Planning Act 2008 (as amended) – Section 51

Application by Immingham Eastern Ro-Ro Terminal Limited for an Order Granting Development Consent for the Immingham Eastern Ro-Ro Terminal

Advice following issue of draft documents.

**Figure 2.1**

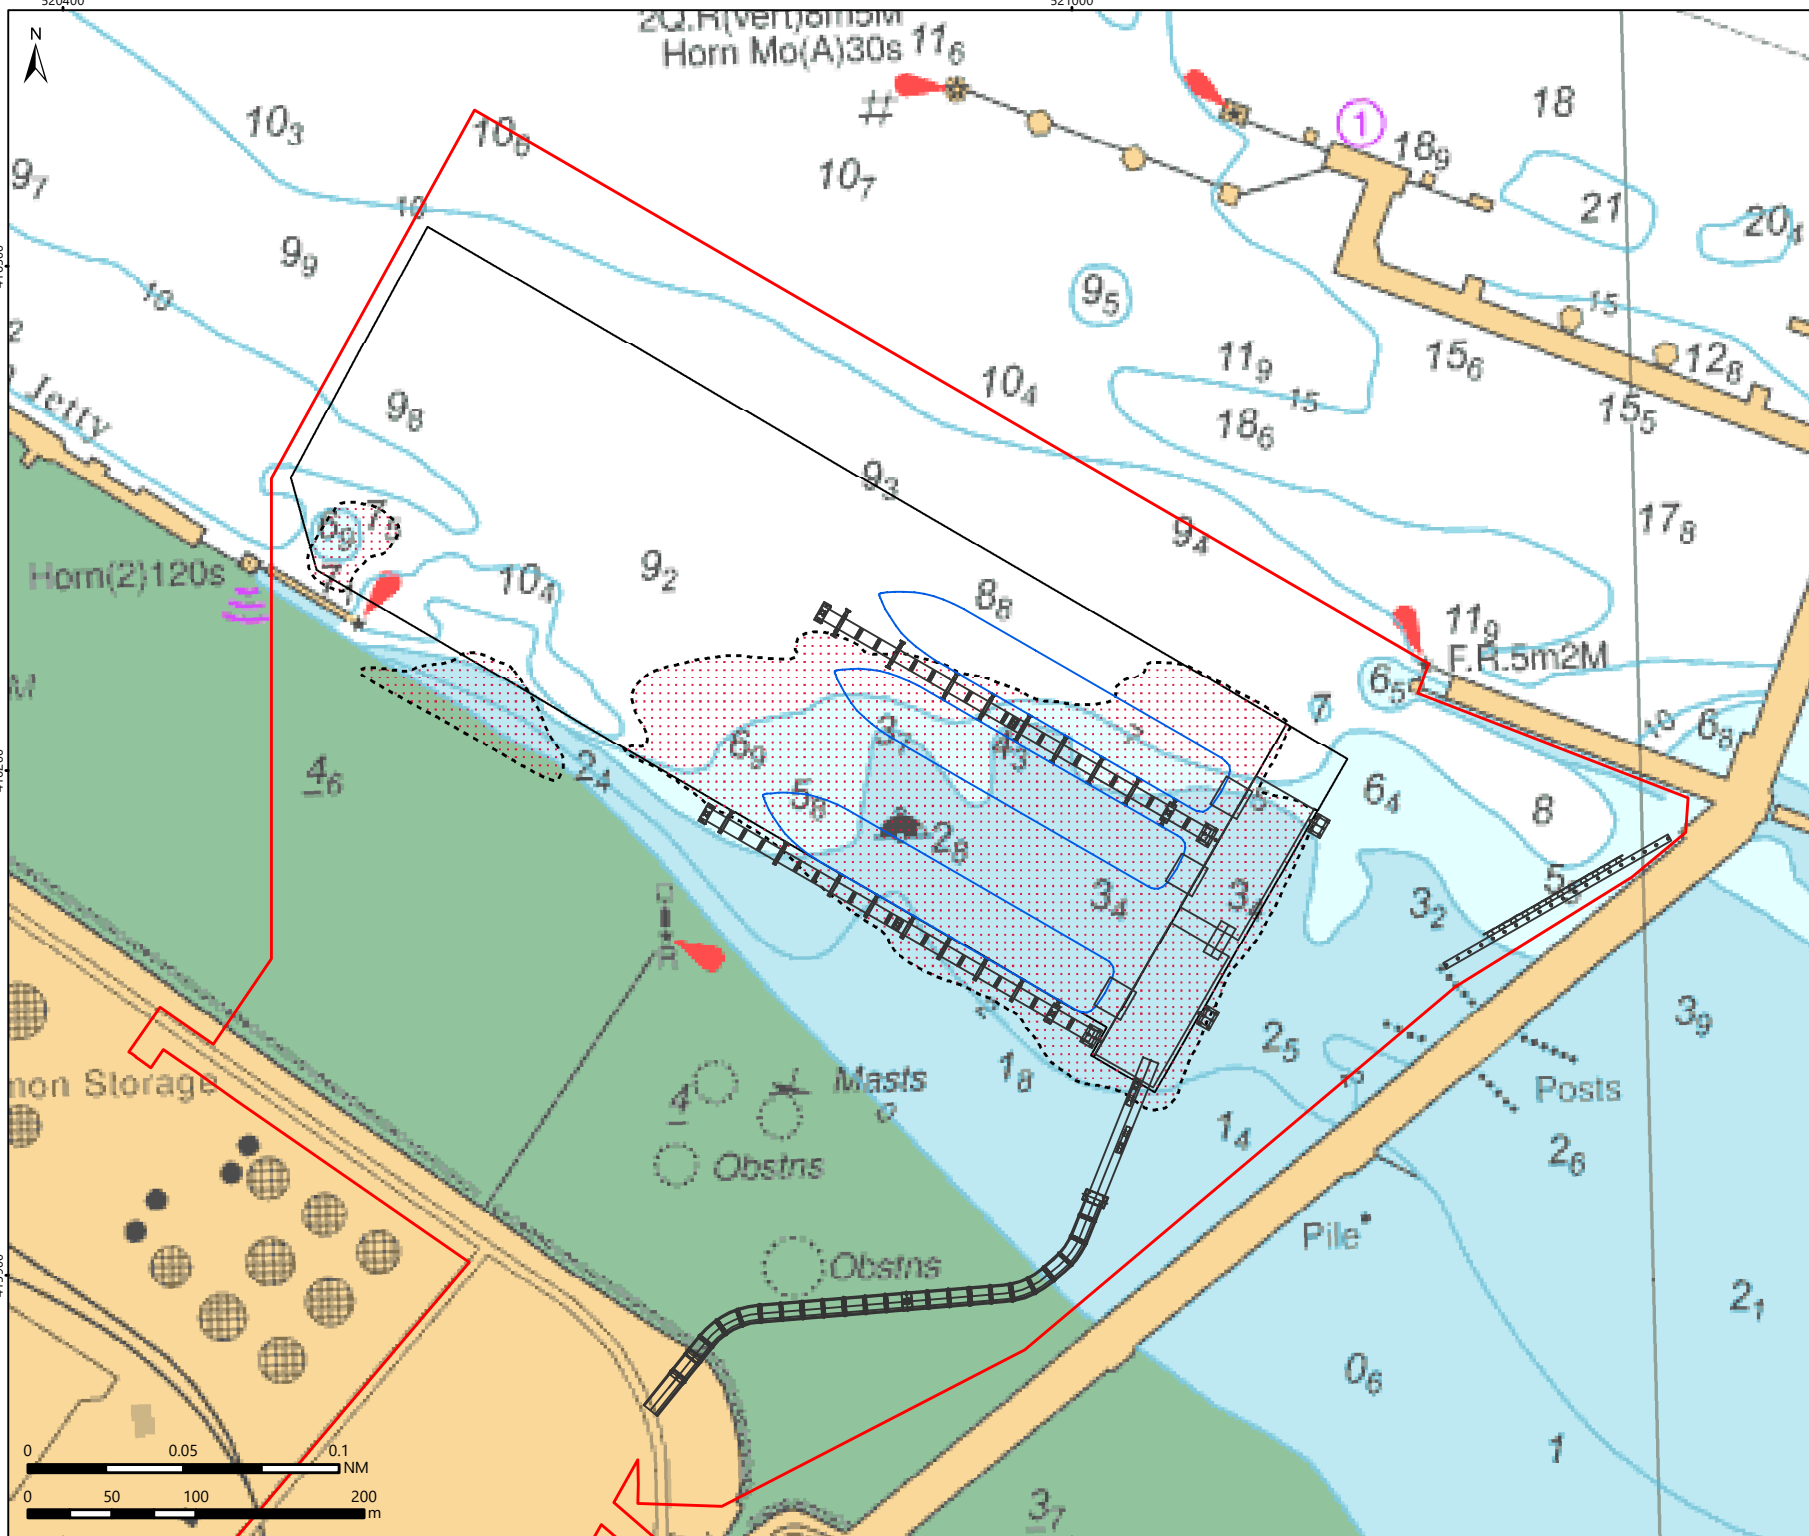
The image is pixelated when zoomed in, it is suggested that a higher resolution image is provided.

**Figure 2.2**

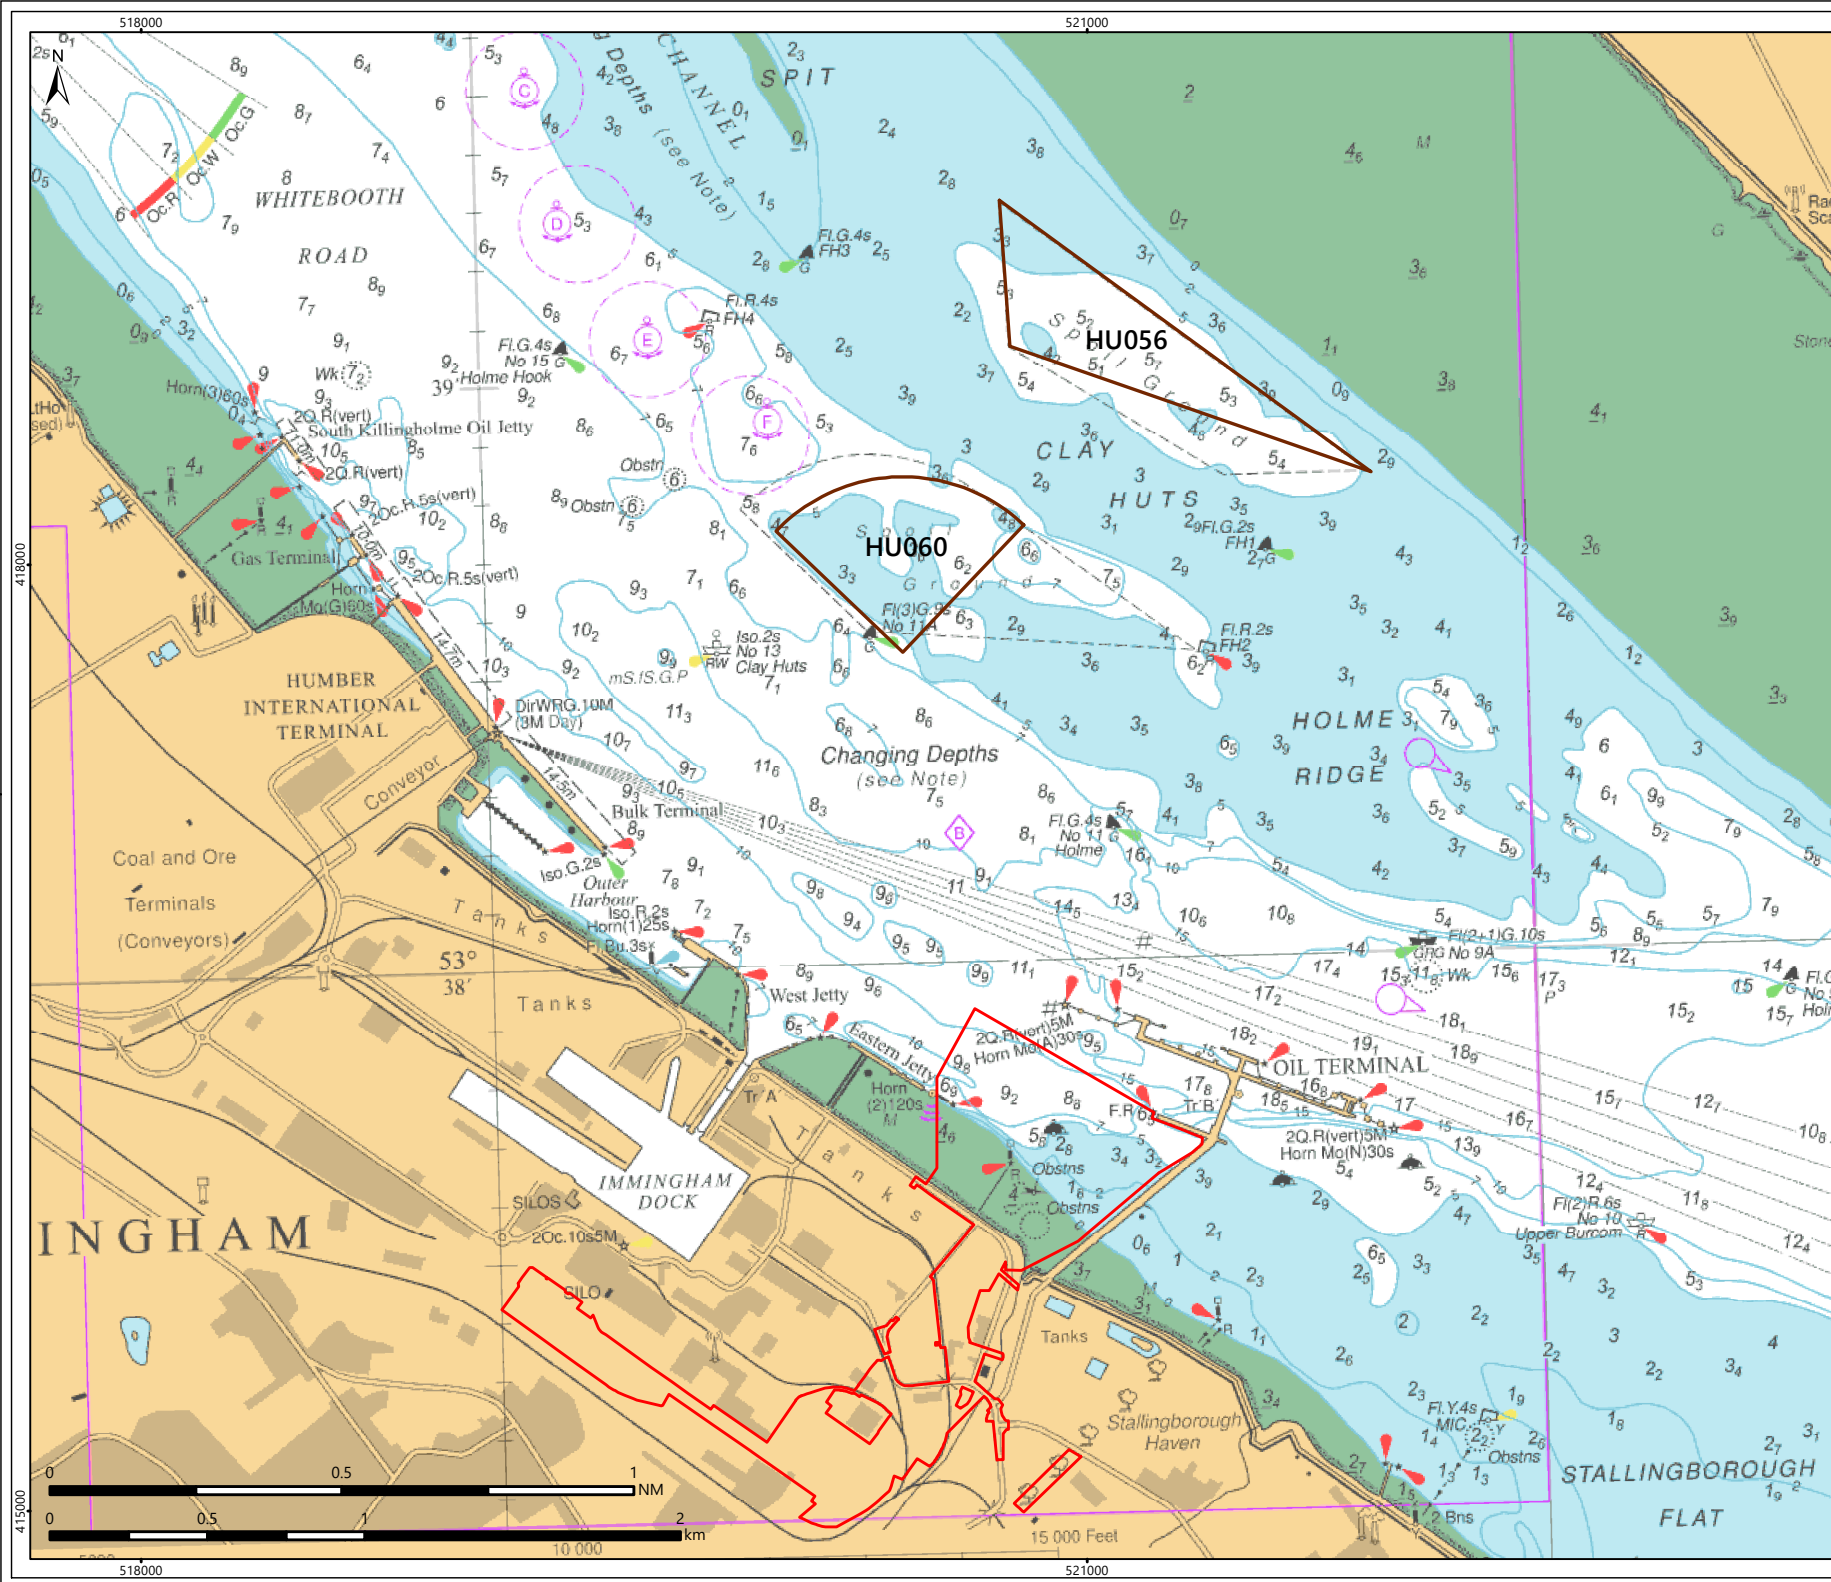
The ES Chapter acknowledges that this image is illustrative, the chapter should specify what elements are fixed. A key should also be provided within the image.
